20 August 2020

RE: SEAR's response Murray River Energy Pty Ltd, Moama Ethanol Plant scoping report.

Thank you for allowing Murray River Council to provide comments in relation to the Murray River Energy Pty Ltd, Moama Ethanol Plant Scoping Report dated 28 July 2020, as a precursor to the Environmental Impact Statement (EIS) process.

INDICATIVE SITE LAYOUT

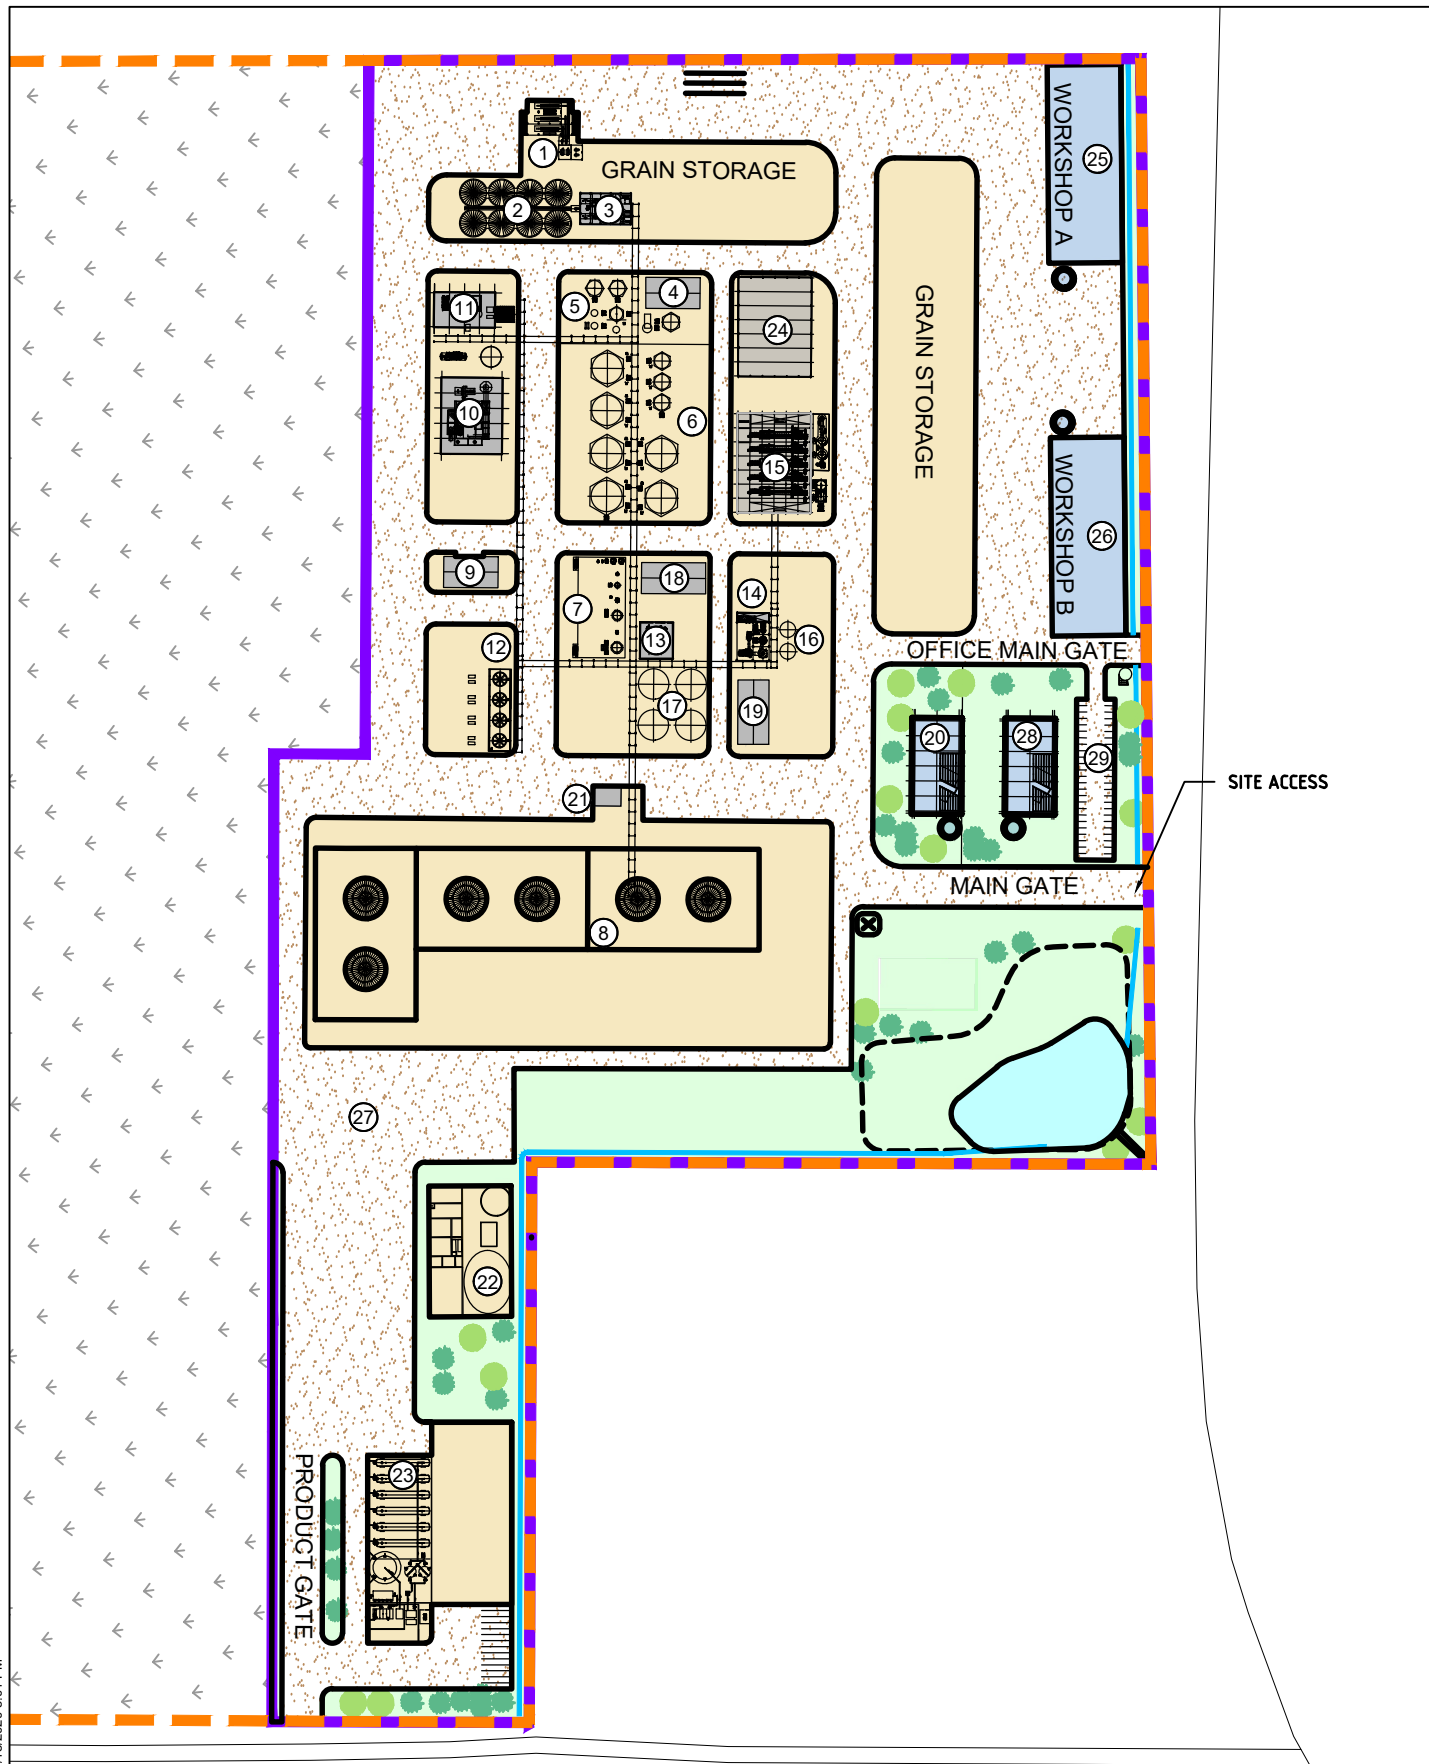
Road/vehicle access and rail freight: Please be advised that Council has concerns regarding proposed access to the subject site. It is noted that Centre Road would be required to be upgraded and widened and also access onto Cobb Highway. Further information is also required in relation to the proposed maneuverability of railway network at the site and any infrastructure/Pedestrian/Traffic considerations or upgrades required through the Moama township area.

Council recommends that the Traffic Impact Assessment Report consider these issues in consultation with both Murray River Council and Transport for NSW.
